DECISION DELEGATED TO HEAD OF PLANNING

Application No:	H16-0543-25	Applicant:	Mr R Campanaro
Proposal:	Residential Development - Erection of Detached Dwelling. Approved under H16-1051-22. Modification of Condition 1 to allow amendments to previously approved plans		
Location:	Tidswell Bungalow Burr Lane Spalding		
Terminal Date:	29th July 2025

Drawing No. 2459.2

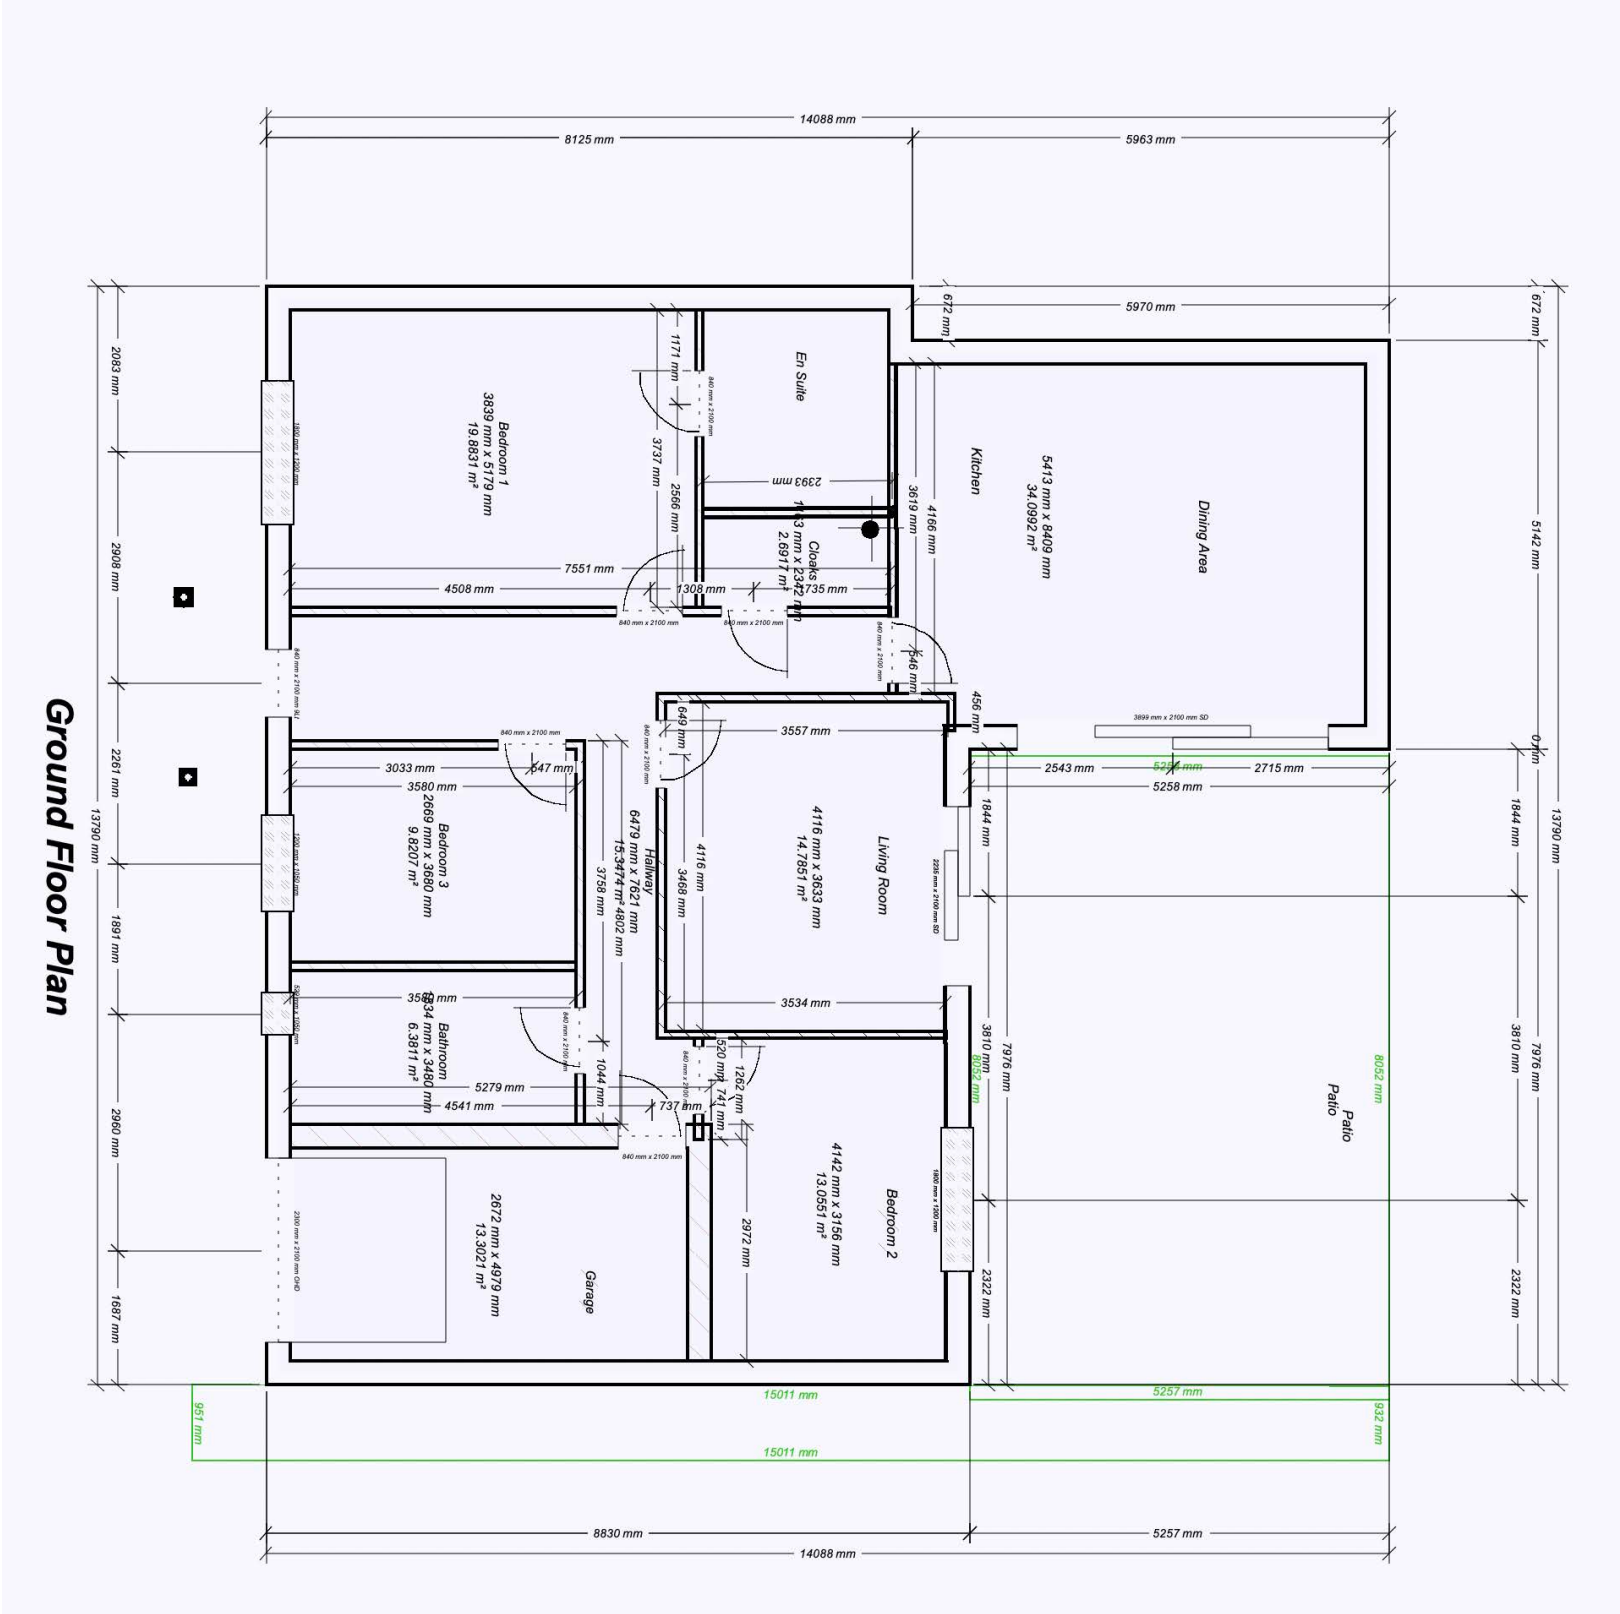
-Concern regarding proximity to boundary fence

While the proposal would sit closer to the eastern boundary, it is considered that the reduction in the height of the building would ensure no significant overshadowing occurs.

Concerns were raised from a member of the public regarding the proximity to the boundary fence shown on the initially submitted plans. The arrangement has been clarified with the Agent, who has demonstrated that a space of 500mm will be left to the boundary. This is considered sufficient to allow for access and maintenance and to prevent any intrusion upon the neighbouring property.

Proposed Side Elevations - 1:100 @ A4

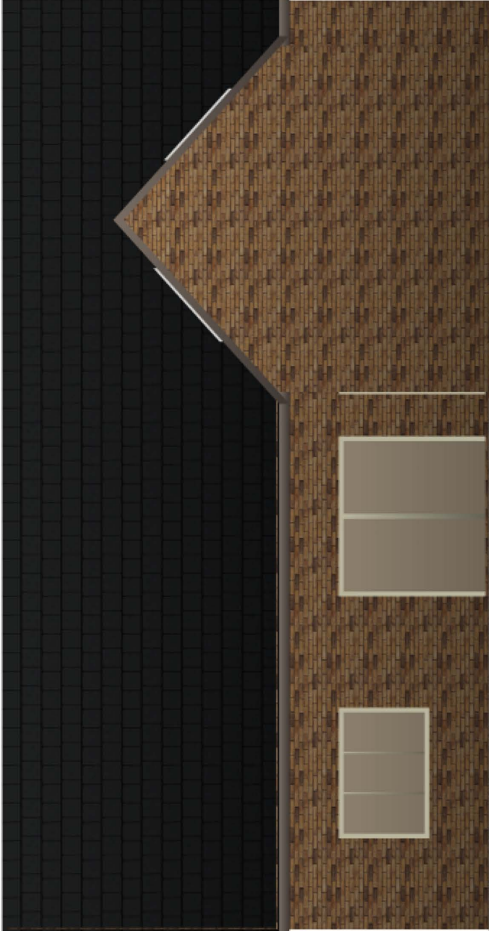
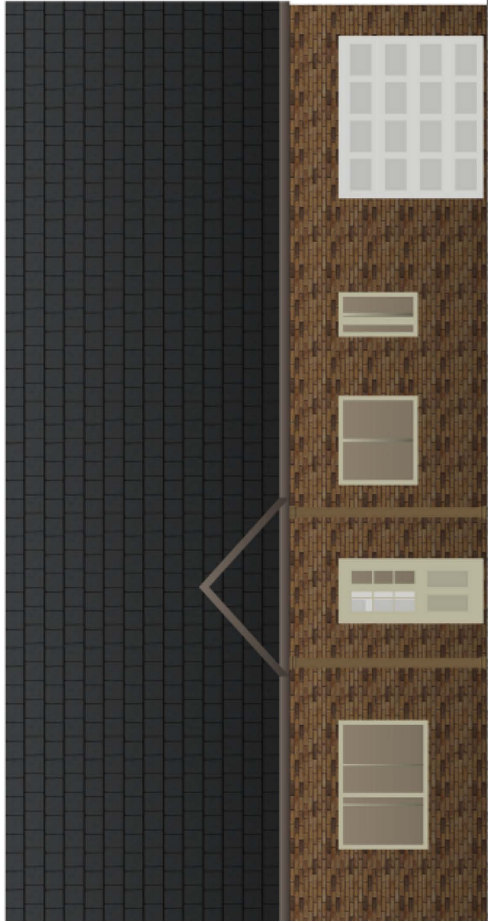
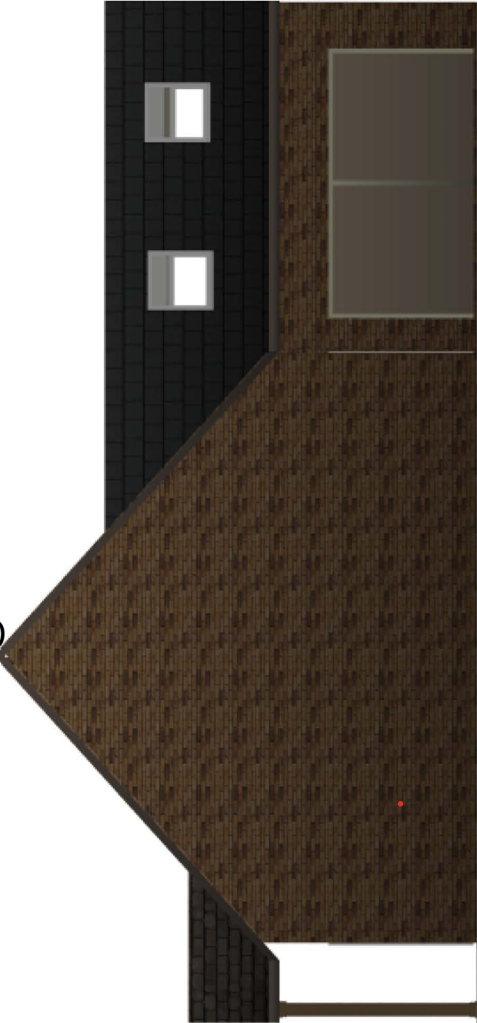
The eastern facing roof lights may result in some views towards the first floor windows of the neighbouring dwelling. However, these would be at an oblique angle, thereby reducing their impact. In any event, as these windows face onto the public realm, comparable views could be achieved from the public realm irrespective of the outcome of this decision. As such, the actual harm is negligible.
